From: Sandra Chapman
Sent: 27 March 2024 12:43
To: Kaleem Janjua
Subject: RE: -24/00168/FUL - 3 Rectory Row

Thank you for the amended information. Unfortunately the block plan is not correct as we require the site location plan and the block plan to have the same footprint. Those that you have submitted do not.

SITE LOCATION PLAN
AREA 2 HA
SCALE 1:1250 on A4
CENTRE COORDINATES: 486646, 167976

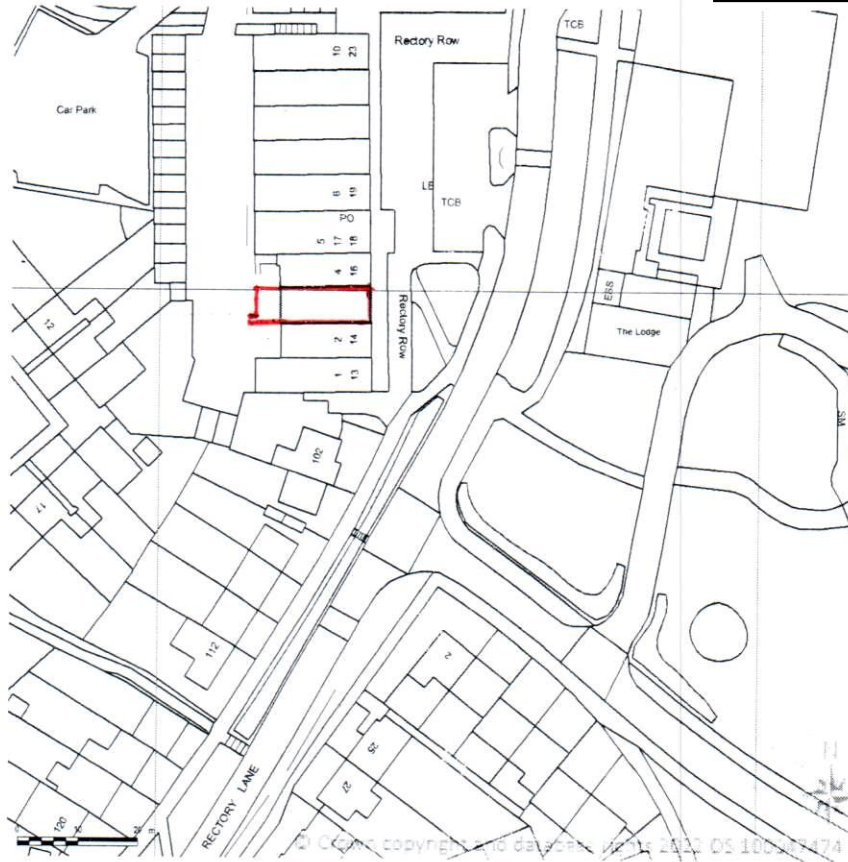
Please can you amend the block plan so that it has the same footprint as the site location plan and use the attached form for Certificate B.
